Application by Highways England**M25 Junction 10 / A3 Wisley Interchange Improvement project****The Examining Authority's second written questions and requests for information (ExQ2)****Issued on 18 February 2020**

Question to:		Question:	
3.	Air quality and human health		Surrey County Council response
2.3.6	Applicant and Local Authorities	<p>Have the air quality implications of the Proposed Development for Ripley been robustly assessed within the ES, having particular regard to the number and suitability of receptor properties that have been used [paragraphs 5.3 and 5.4 of REP1/041] and the extent to which the Applicant's modelling has been verified and modified against the monitoring data that is available for Ripley?</p> <p>With regard to the statement in REP2-022 that the largest change was assessed to occur at Receptor 6 but was classed as 'small', please explain the significance of this change in EIA terms and whether it affects the conclusions of the ES.</p>	This is not a matter on which SCC can comment. Air quality monitoring and management is a District and Borough responsibility and therefore GBC and EBC are the planning authorities with access to the relevant expertise

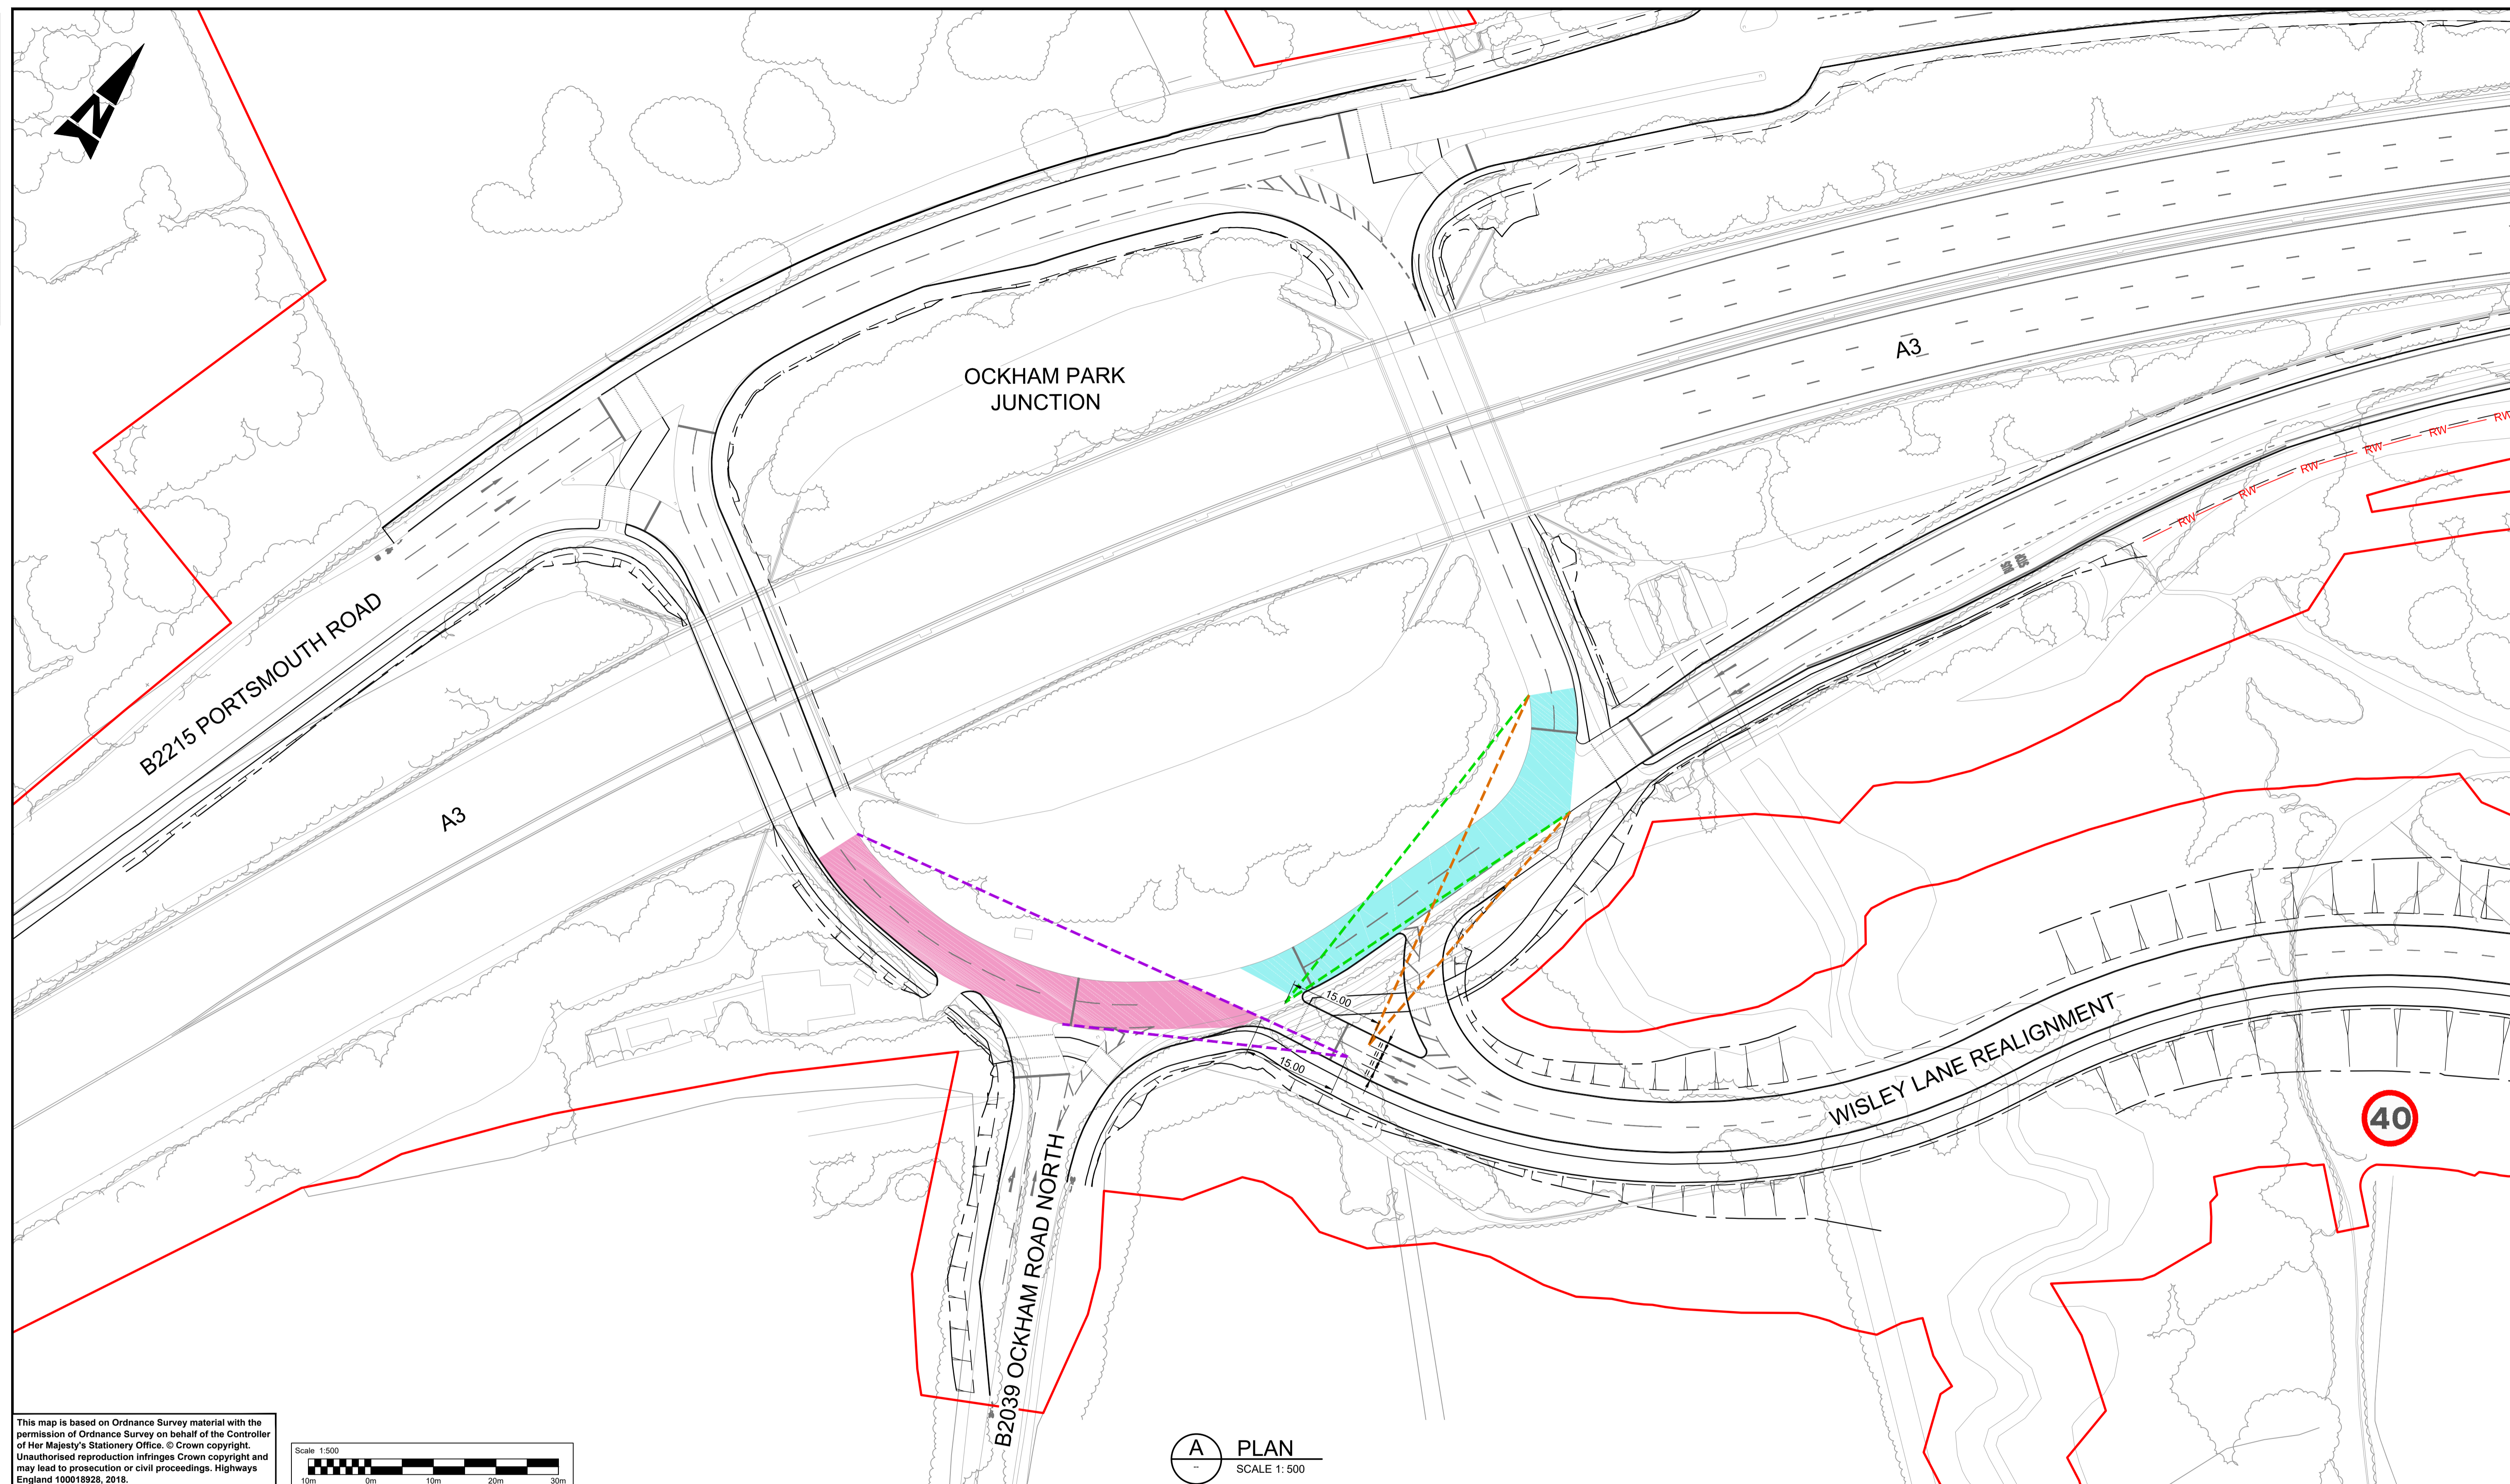
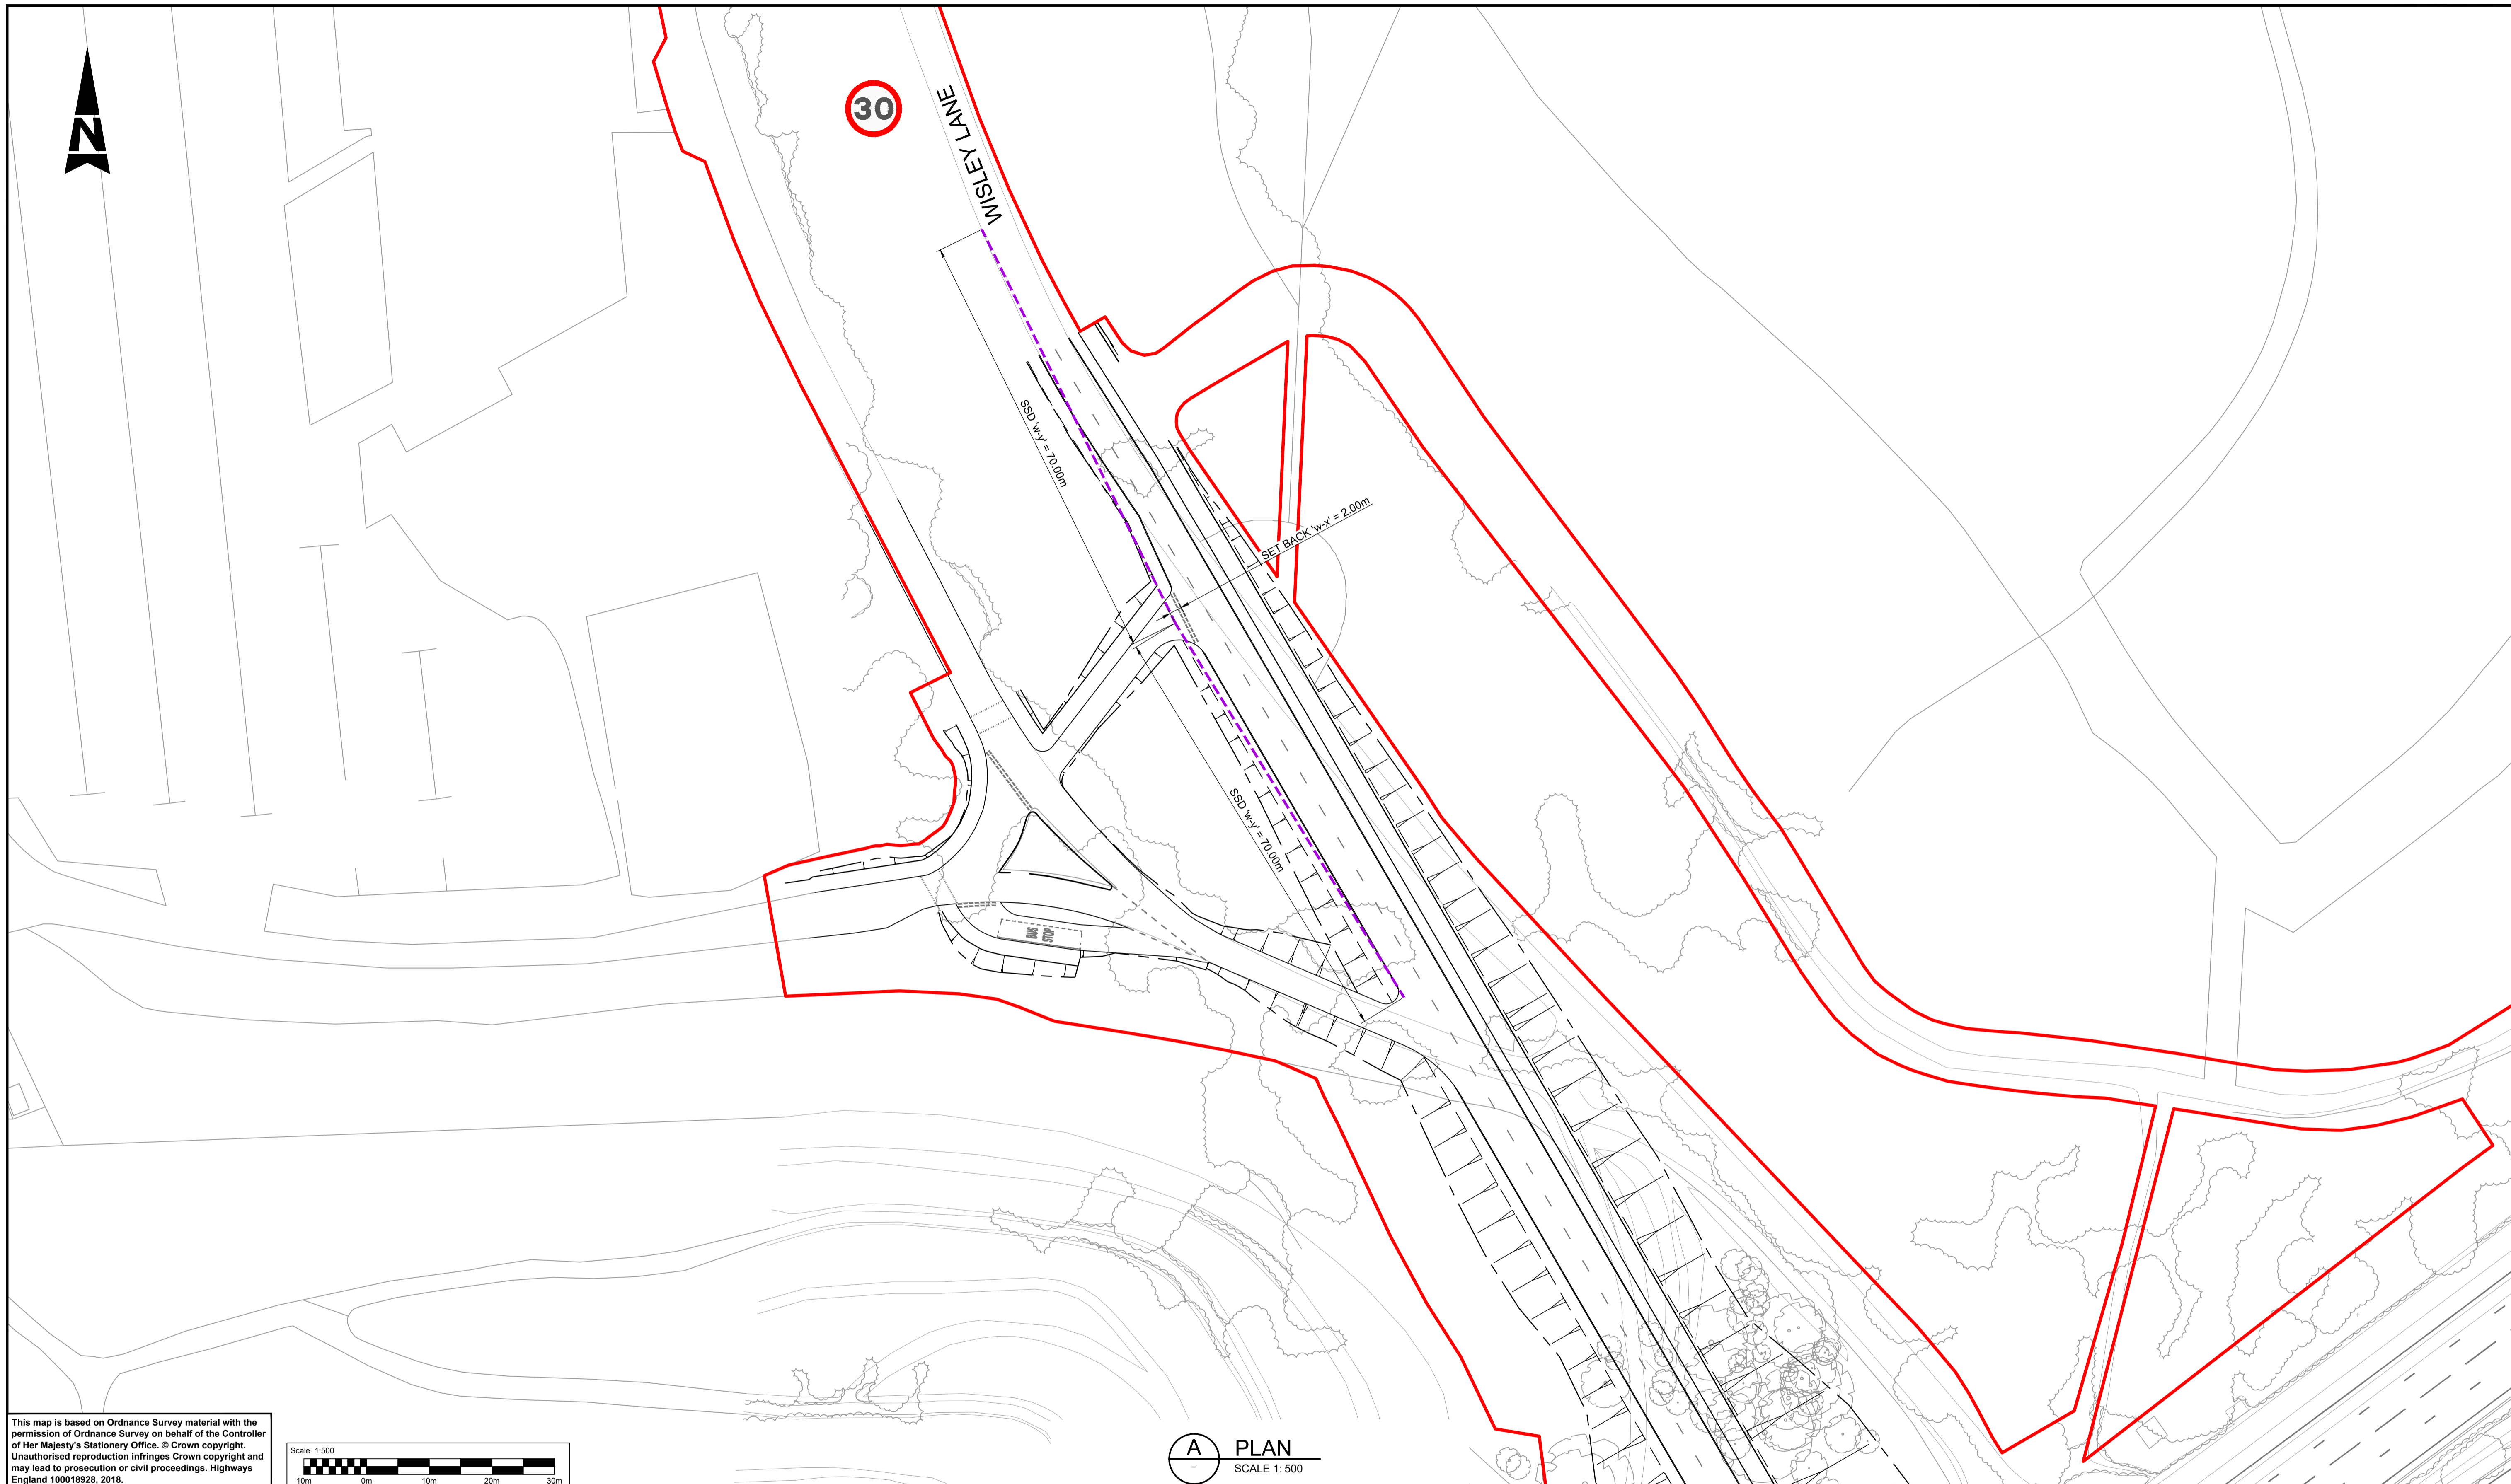
<p>b) The plots that SCC have seen do not meet the required standards, so SCC would like to see the mitigation measures that the applicant is proposing. Under Construction (Design and Management) regulations (CDM Regs), Highways England are the designer and measures are therefore to be determined by the proposer.</p> <p>SCC also consider that this is a consideration to measure on site for actual conditions, as the plans will not allow seasonal variations e.g. to vegetation.</p> <p>c). Vegetation clearance appears to be required beyond the red line. This raises a number of issues as the works are outside the DCO boundary. The proposed work to improve sight lines impact SCC land that is managed by Surrey Wildlife Trust on SCC's behalf. It is SSSI and SPA and the proposed works are not covered in the EIA or HRA. SCC assume these need to be assessed and included as an addendum to each document. SCC would also like to be assured that Natural England have no issues with these proposals as a local authority, we have a duty to engage with the Habitats Regulations.</p> <p>Regarding the works themselves, SCC assume these could take the form of tree and scrub removal across the inside of the bend. SCC acknowledge that this could improve light reaching the pond and reduce leaf fall into it, both being beneficial. There is a mix of pines and deciduous trees, the pines can be simply felled and they will not regrow. However, the</p>	Design speed kph	120	100	85	70	60	50	V2/R	Stopping sight distance (metres)								Desirable minimum	295	215	160	120	90	70	-	One step below desirable minimum	215	160	120	90	70	50	-
Design speed kph	120	100	85	70	60	50	V2/R																												
Stopping sight distance (metres)																																			
Desirable minimum	295	215	160	120	90	70	-																												
One step below desirable minimum	215	160	120	90	70	50	-

Question to:		Question:
		<p>splays could be provided on either side of Elm Lane's junction with Old Lane?</p> <p>c) Drawing HE551522-ATK-HGN-XX-SK-CH-000036 within Appendix A of REP4-006 shows visibility splays drawn to accord with DMRB CD109 and CD123 standards inclusive of some vegetation clearance. To achieve the DMRB standards would the required vegetation clearance shown on drawing HE551522-ATK-HGN-XX-SK-CH-000036 be within or extend beyond the red line areas for land plots 24/4 and 24/4a shown on sheet 24 of AS-002?</p> <p>d) If visibility splays of the relevant standard would be unachievable within the extent of land</p>
		<p>deciduous trees will coppice and form dense regrowth very quickly after cutting unless the stumps can be removed or treated. They will be difficult to treat due to the proximity to water and this may not be possible. This dense regrowth will effect visibility and will require more regular maintenance. These are maintenance responsibilities that will fall to SCC and so SCC would require suitable maintenance monies to be provided to cover this ongoing maintenance.</p> <p>d) .SCC consider that the main issue is right turning traffic entering Elm Lane not being seen by following southbound traffic (i.e. drivers of following vehicles with restricted sightlines will not be able to view a stationary vehicle waiting to turn right).</p> <p>Before any meaningful measures can be suggested, the available stopping sight distance/visibility envelope should be measured to confirm what can be achieved. If the stopping sight distance is one, or even two or more steps, below desirable minimum then it is a creating a known concern / setting a precedent. Typical remedial measures that SCC's Safety Engineering team could employ in such situations on an existing highway concern would be high friction surfacing, appropriate junction warning signing with distance plates, slow road markings.</p> <p>In addition, an issue which has not been raised is the concern for two-way traffic in Elm Lane. If a vehicle attempts to enter Elm Lane at the same time a vehicle wishes to exit, there does not appear to be with width in the side road to accommodate two lanes of traffic. This could result in stationary traffic waiting to turn right, waiting in Old Lane (potentially for prolonged periods if several vehicles exit Elm Lane at once). Also it could result in vehicles reversing back from Elm Lane onto Old Lane. SCC query whether the bellmouth needs to be widened to allow two-way traffic as well as passing places in Elm Lane.</p> <p>SCC also has concerns regarding the achievable forward sight stopping distance/visibility envelope at the A3 northbound off slip to A245 Byfleet Road within the red line boundary due to the change from a signal controlled arrangement to a free flow jet lane. This concern is also stated in our covering letter.</p>
